From: Tim Screen
Sent: 13 September 2019 11:39
To: Caroline Ford
Subject: Exemplar Public Open Space
Attachments: TIN014 edition 2.pdf

Frontage to Banbury Road

DRAWING TITLE:
**NORTH FRONTAGE
SOFT LANDSCAPE PLAN
FINAL SCHEME**

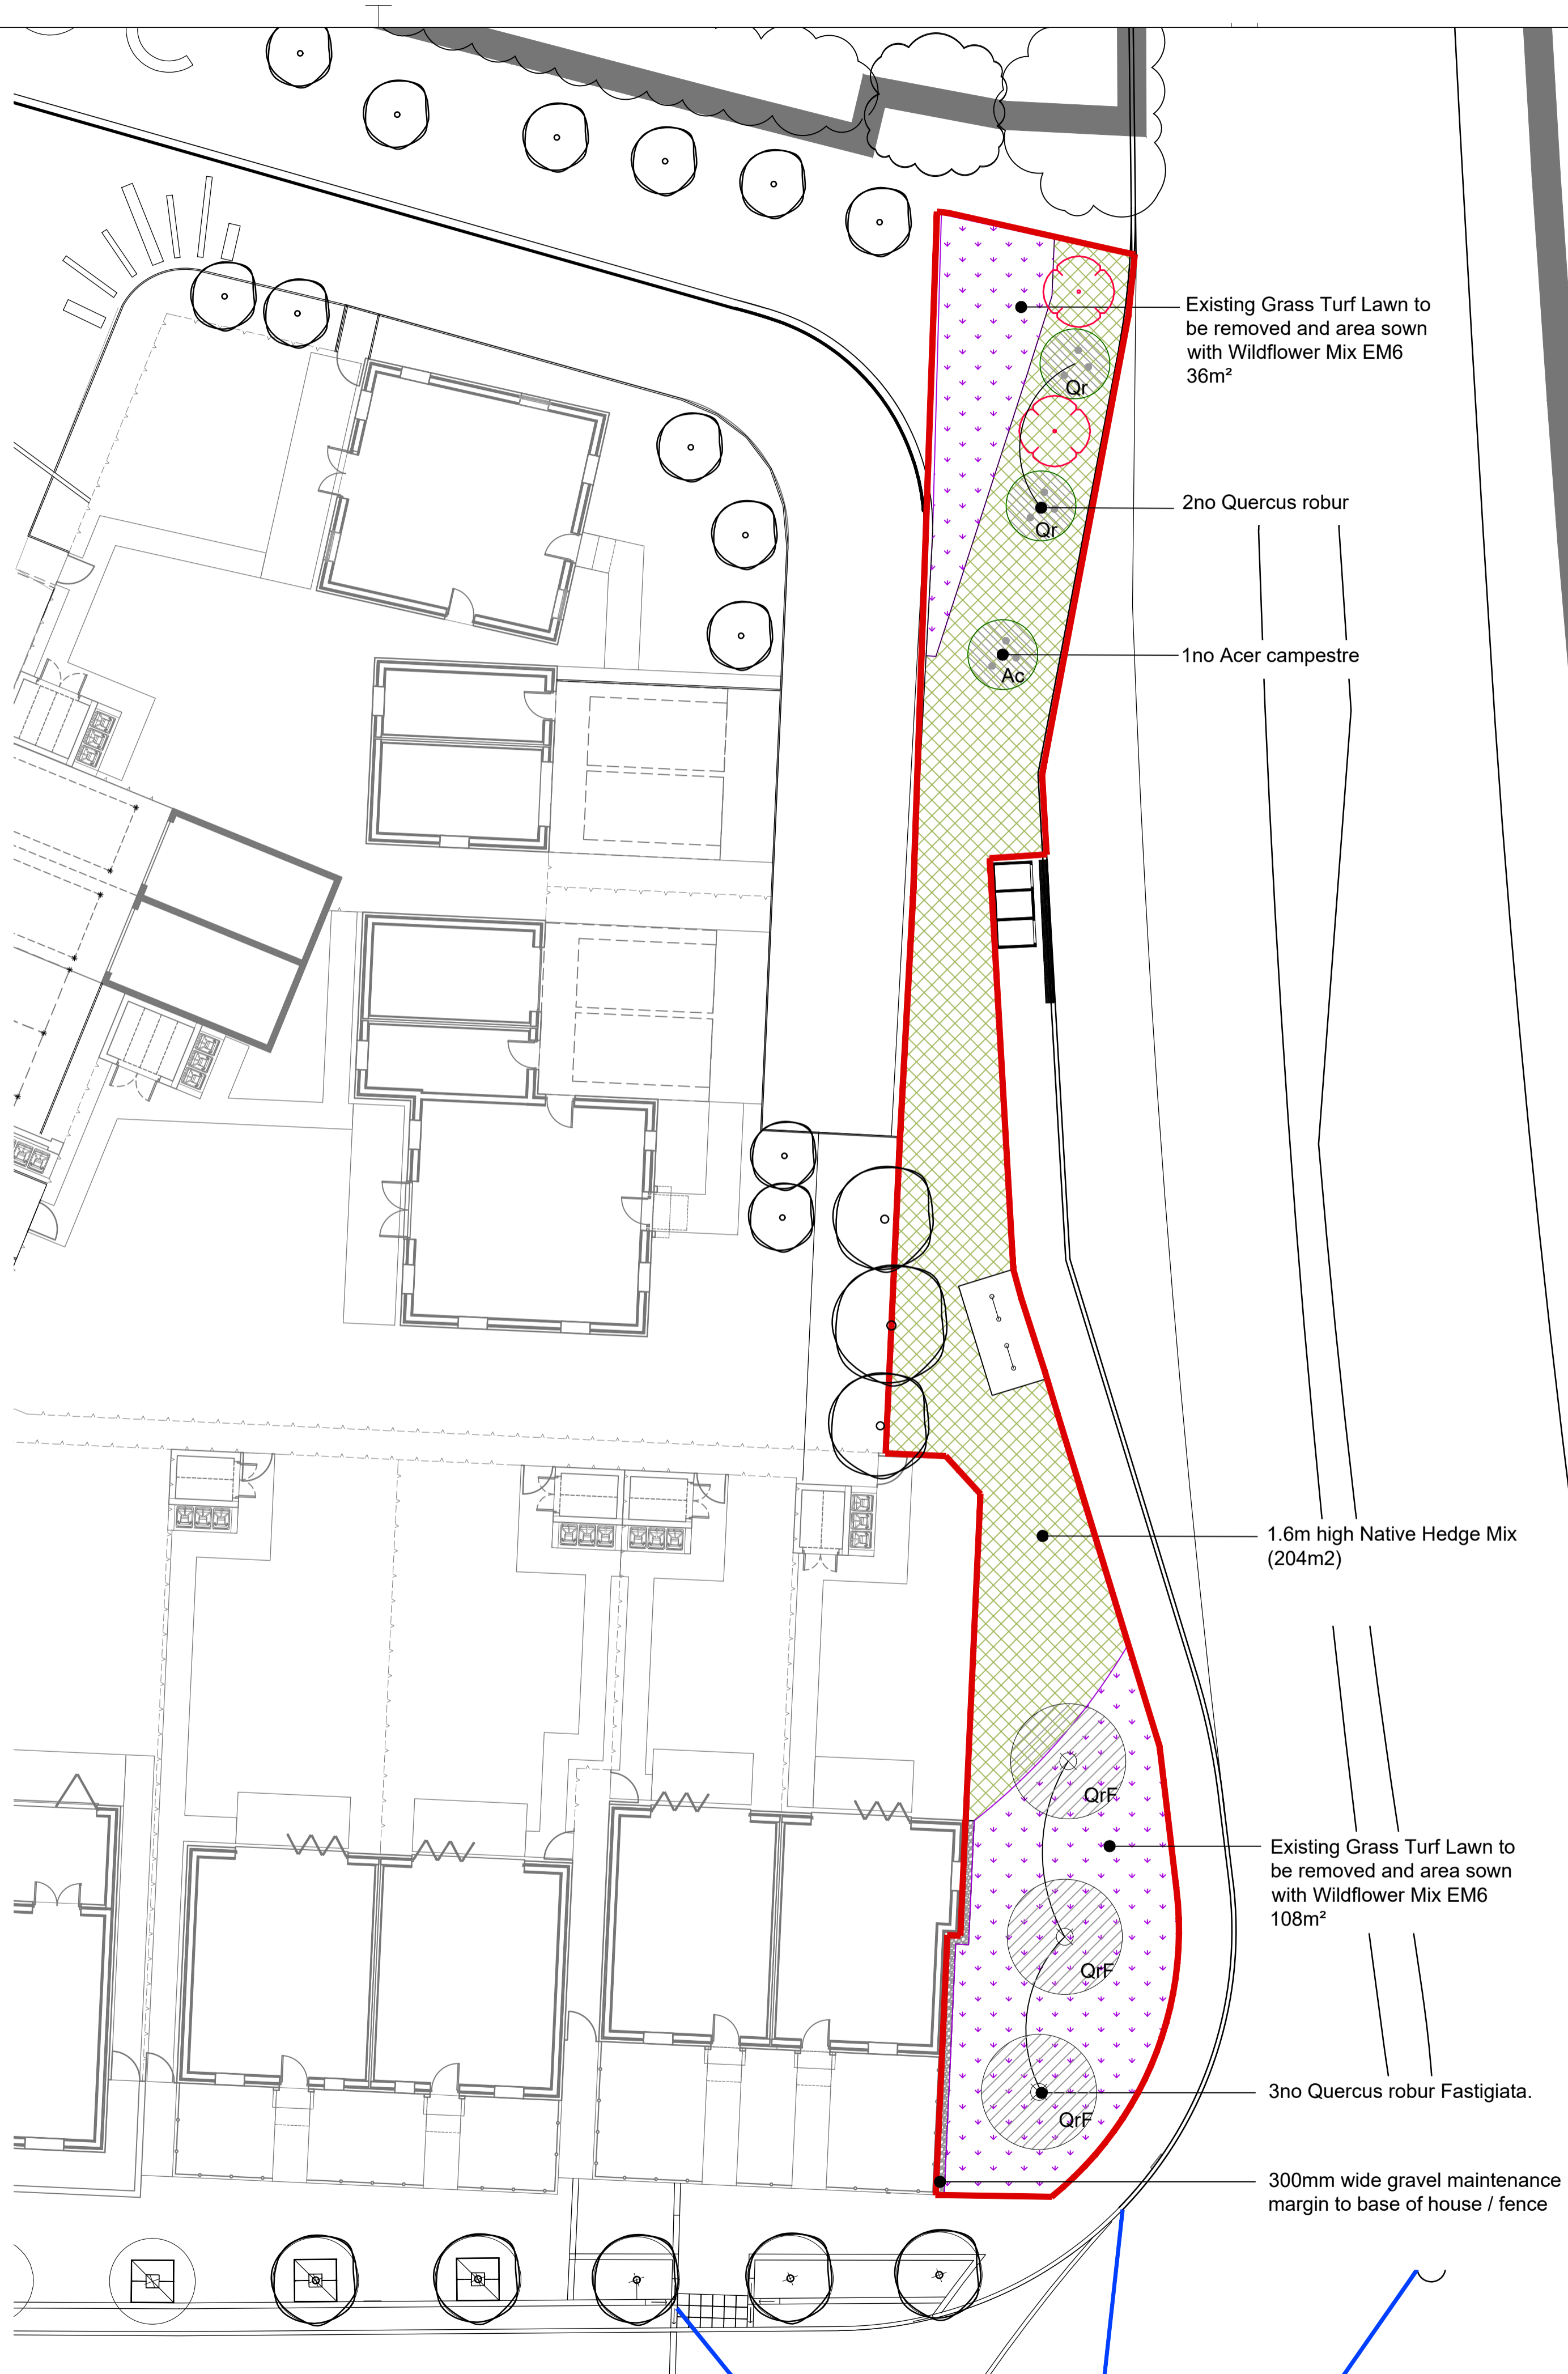
1. The change of level between the bus stop and the finished floor level make the mowing of the grass verge a risk to operatives. I suggest the with the 1 m wide grass verge (to prevent overhanging vegetation from the thicket impeding access on the footpath) the immediate area to the rear of the bus stop where this slope is a problem I propose that a low cushion of *Lonicera pileata* is planted round the rear of the shelter.

2. For the purpose of maintaining surveillance of the bus stop for safety reasons from the widows of adjacent dwellings the thicket should be maintained to height of 0.8 m. Regular trimming for certain native shrubs encourages a dense canopy of twigs and leaves which is the effect to aim for in this location. I suggest native hawthorn and holly for this purpose.

DRAWING TITLE:  
**SOUTH FRONTAGE  
SOFT LANDSCAPE PLAN  
FINAL SCHEME**

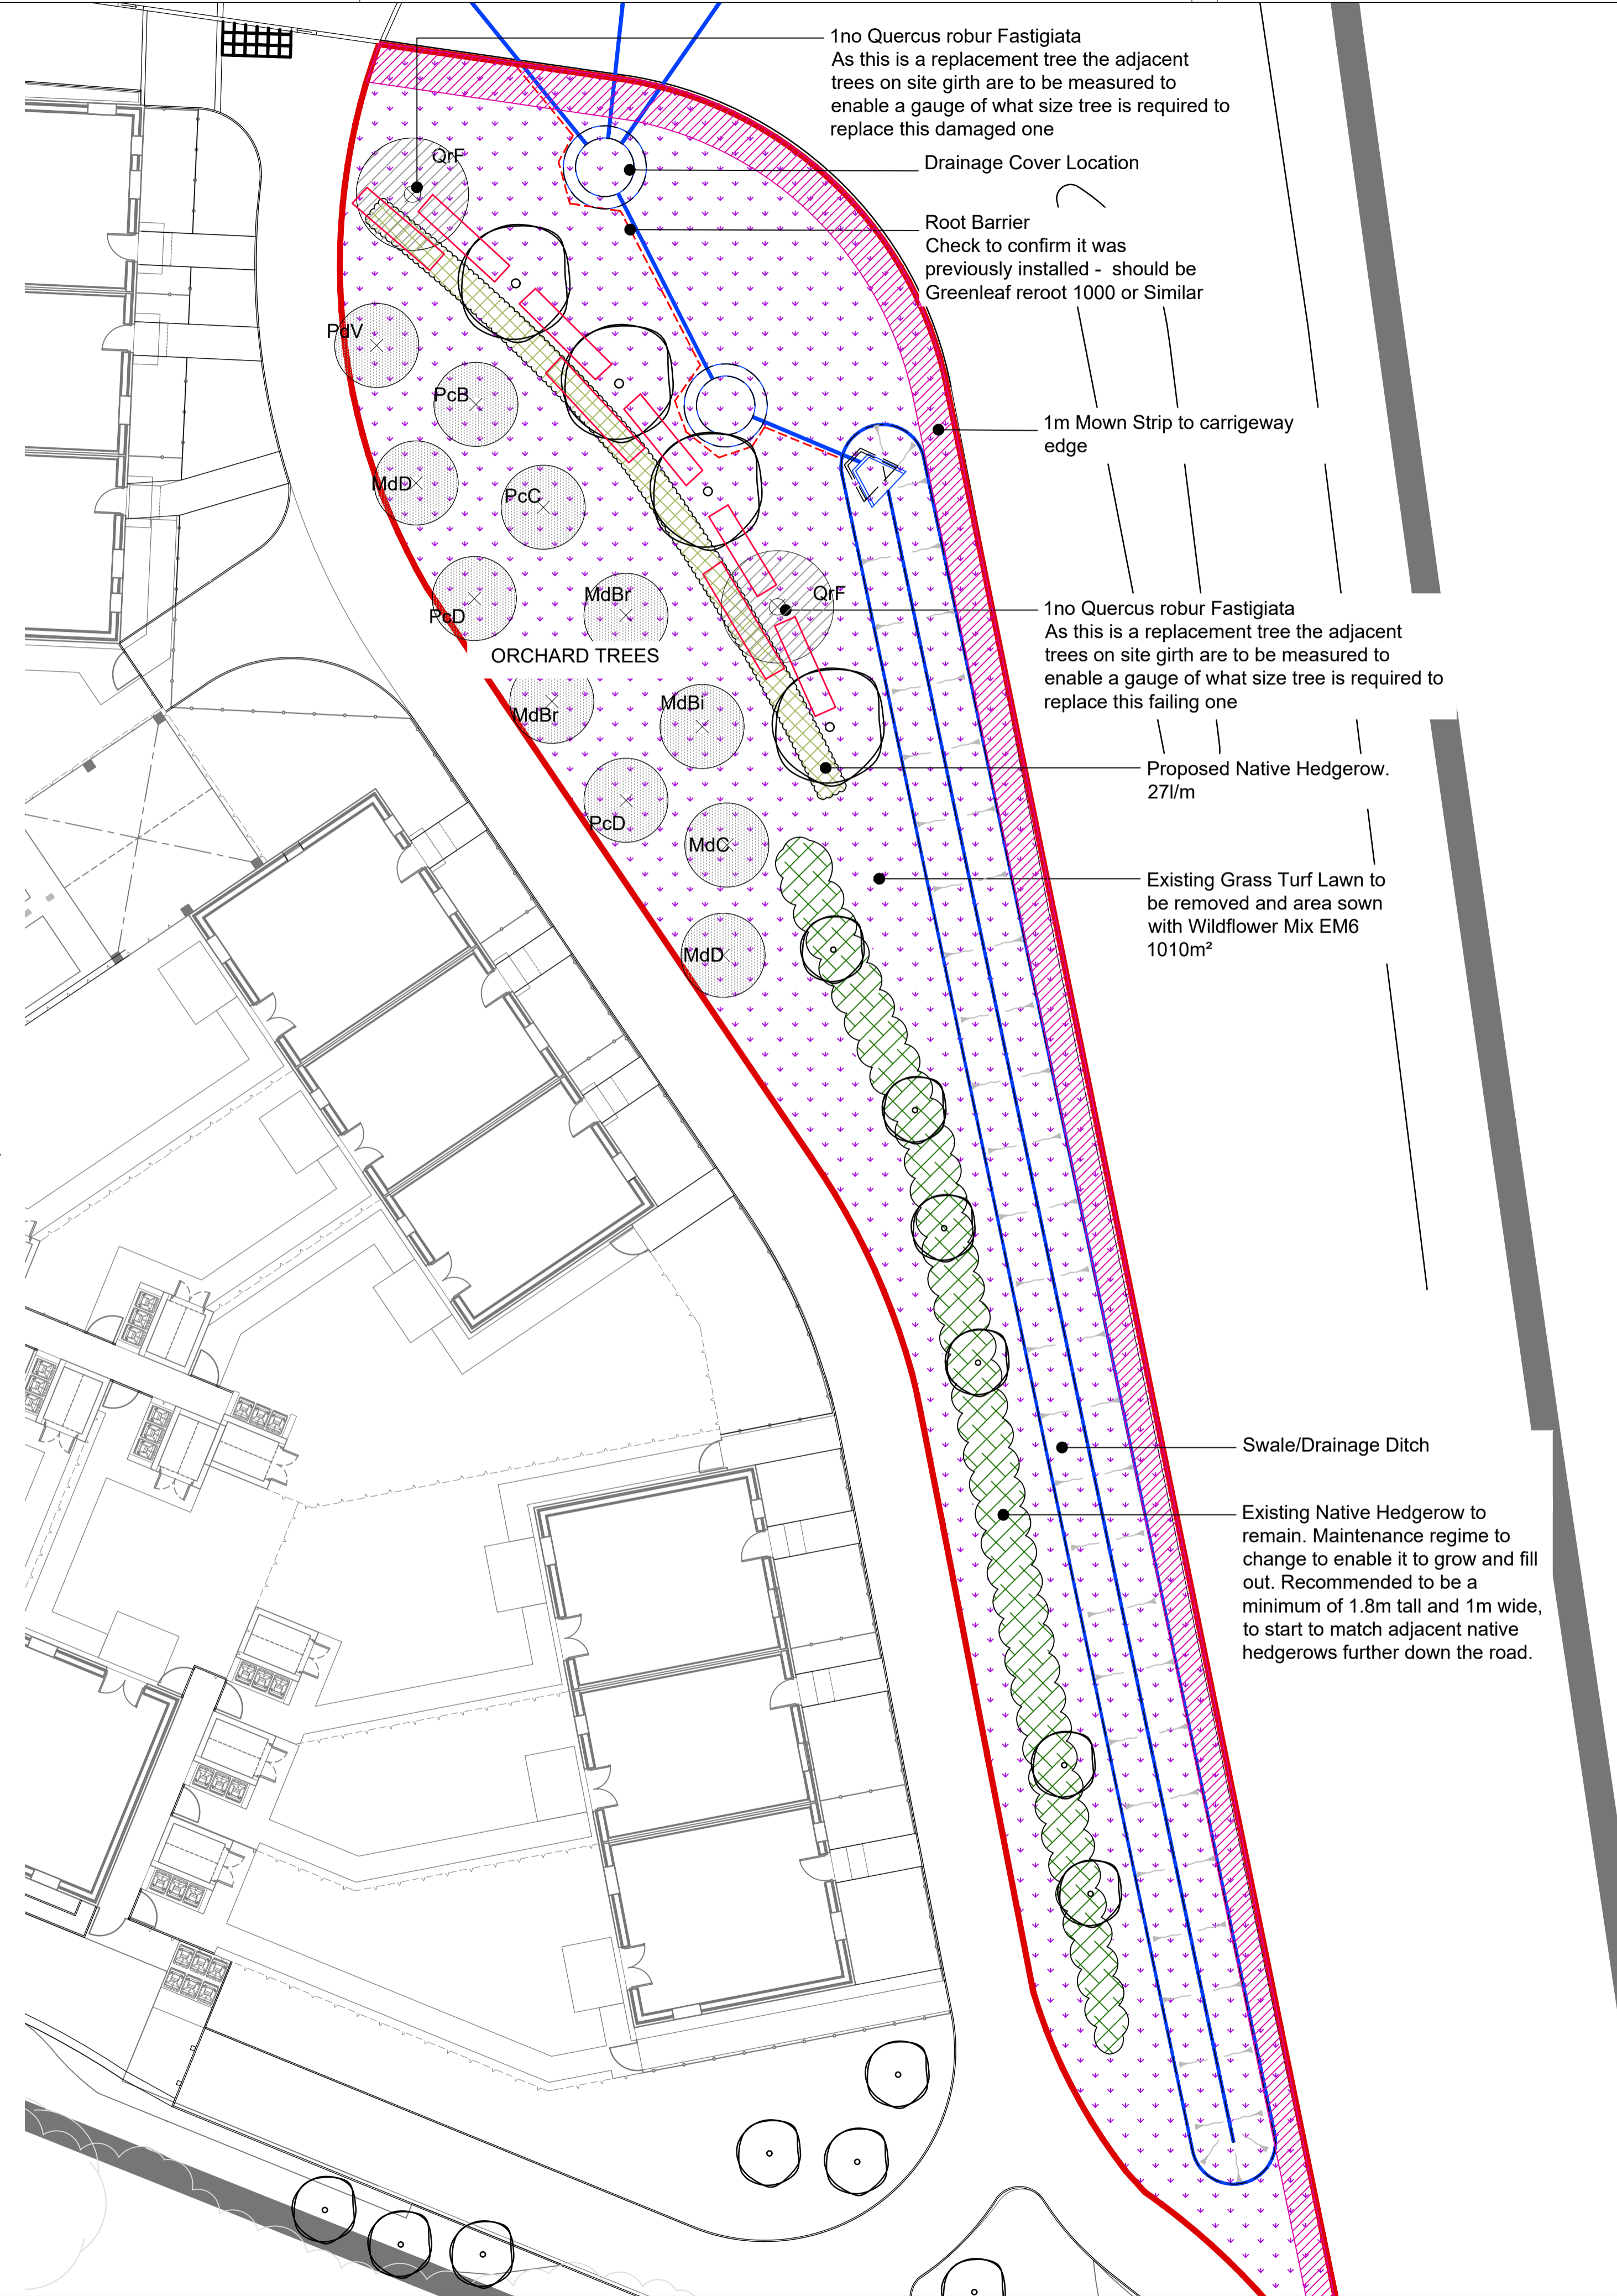
3. Replace the dead *Carpinus Frans* and remove the Portuguese Laurel hedge, and plant a double staggered row of Hornbeams as a hedge 45 cm apart and 45 cm between rows (using the trench system with good quality topsoil and soil conditioner) The hedge will retain its leaves in autumn the and provide a degree of shelter for the new fruit trees during pollination of flowers The forma hedge to be maintained to a height of 1.5 metres.

4. Local apple tree varieties grafted on to a dwarfing M27 rootstock is the requirement. I suggest just three trees planted 4 -5 m apart in a row will suffice. Because the ground is very compacted and survival of tree in these conditions is not guaranteed I suggest that a 3 m wide trench is dug with the arisings removed off site a and good quality topsoil added. Guidance is given with the Natural England guidance on orchards – refer enclosed. Bark mulching is required after the initial watering in.
